Director of Development Services
Ribble Valley Borough Council
Council Offices
Church Walk
Clitheroe BB7 2RA

Drafted 10 April 2012

**Planning Application, Ribble Valley District
D3-12-0255 Chadwicks Farm, Settle Road, Bolton by Bowland**

drawing:
Proposed Site Plan

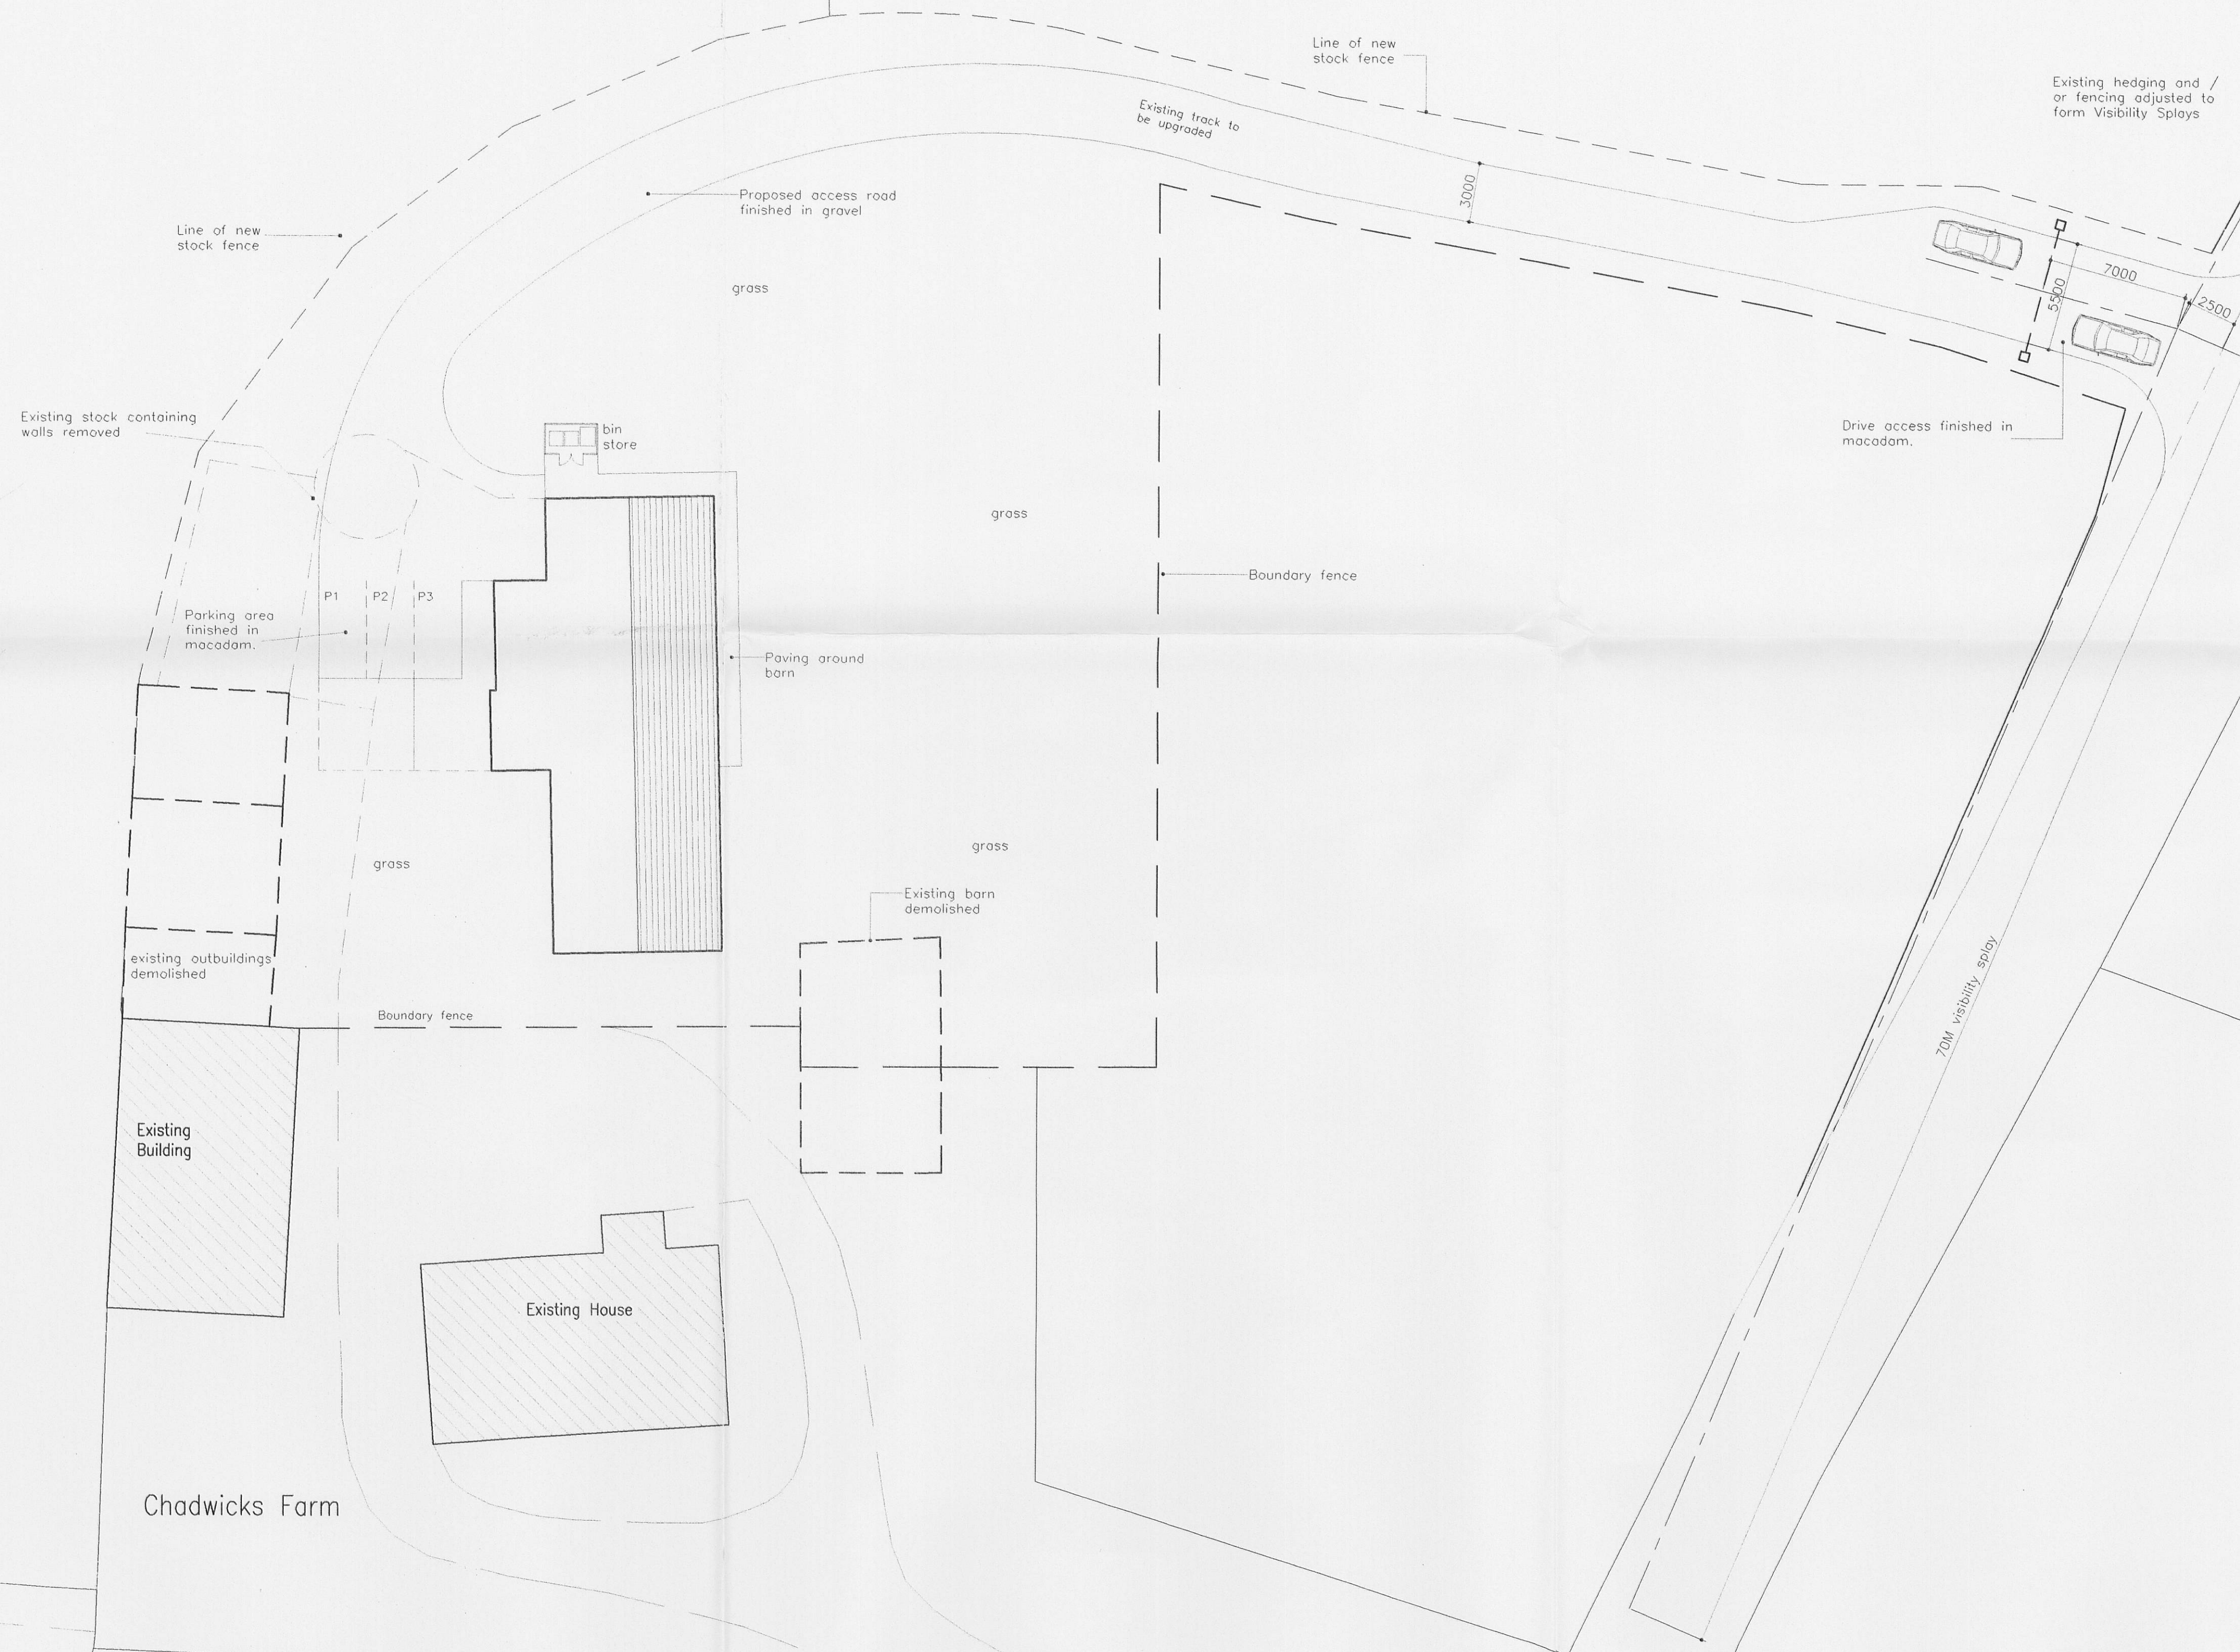
The proposed access will provide satisfactory sightlines for emerging vehicles and is of sufficient width to make provision for vehicles to pass within 10m of the junction. Beyond this, the 3m width for the remainder of the access is acceptable for the anticipated levels of use.

There is adequate parking provided within the site for a minimum of three cars.
